From: [REDACTED]  
Sent: 26 January 2020 13:06  
To: Planning <Planning@arun.gov.uk>  
Subject: Ref FG/148/19/HH

I live at 15 Sark Gardens & I wish to object to the application for the following reasons as there are a number of false/misleading statements made.

14C2 v2

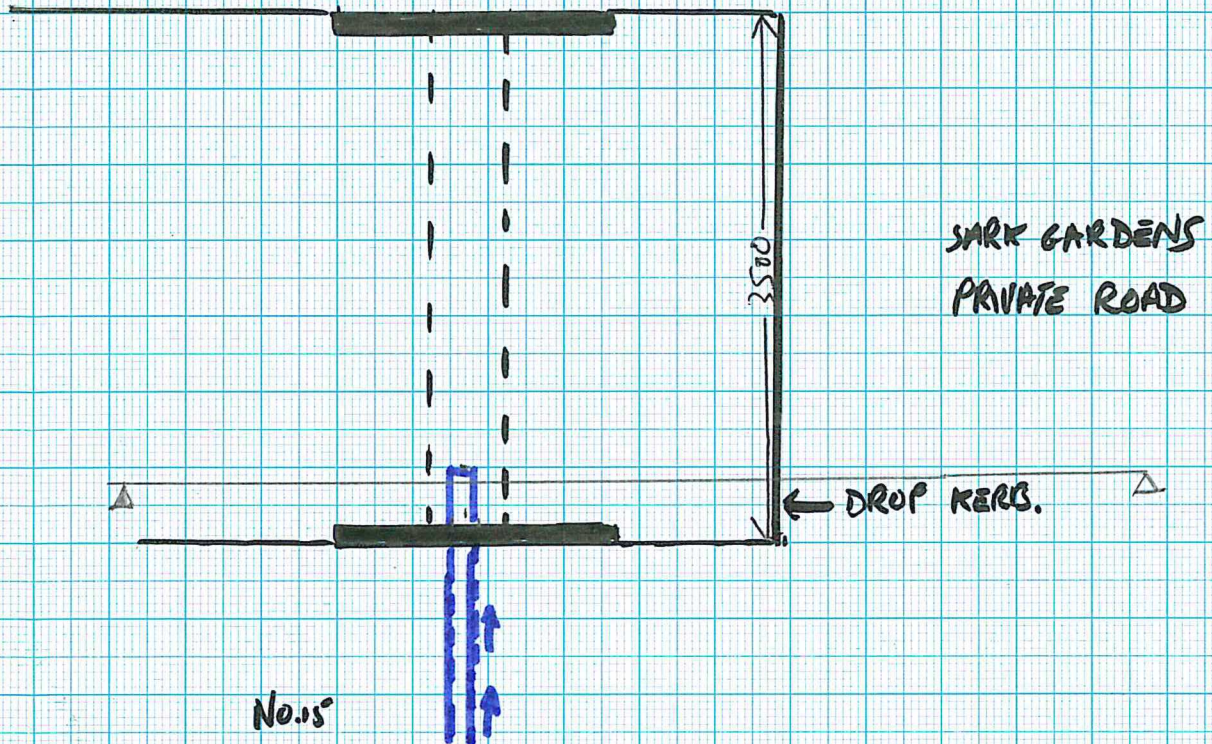
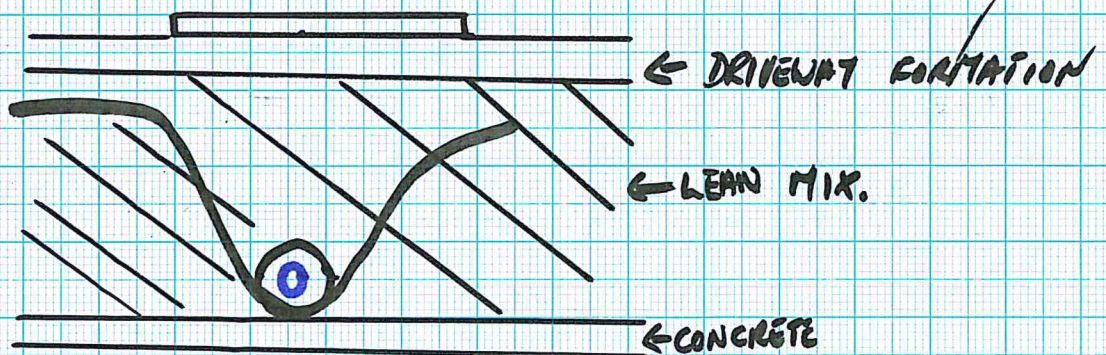
- 1, Plans 14CV2 shows flow Eastwards but it actually flows Westwards from the ditch.
- 2, Site plan does not actually show applicant owning original driveway, so if the applicant doesn't has he asked owners permission to resurface that driveway?
- 3, On statements if applicant had asked (FRSA) Ferring Road Scheme Association he would have found out pipe is not redundant but carries water away from the ditch Westwards to end of Sark Gardens then Northwards along Jersey Road & under Beehive Lane into Little Paddocks.
- 4, Please find enclosed photos taken 20th of December 2019 when ditch was completely full & flooded road, pouring more concrete into an already inadequate ditch will only exacerbate the problem!
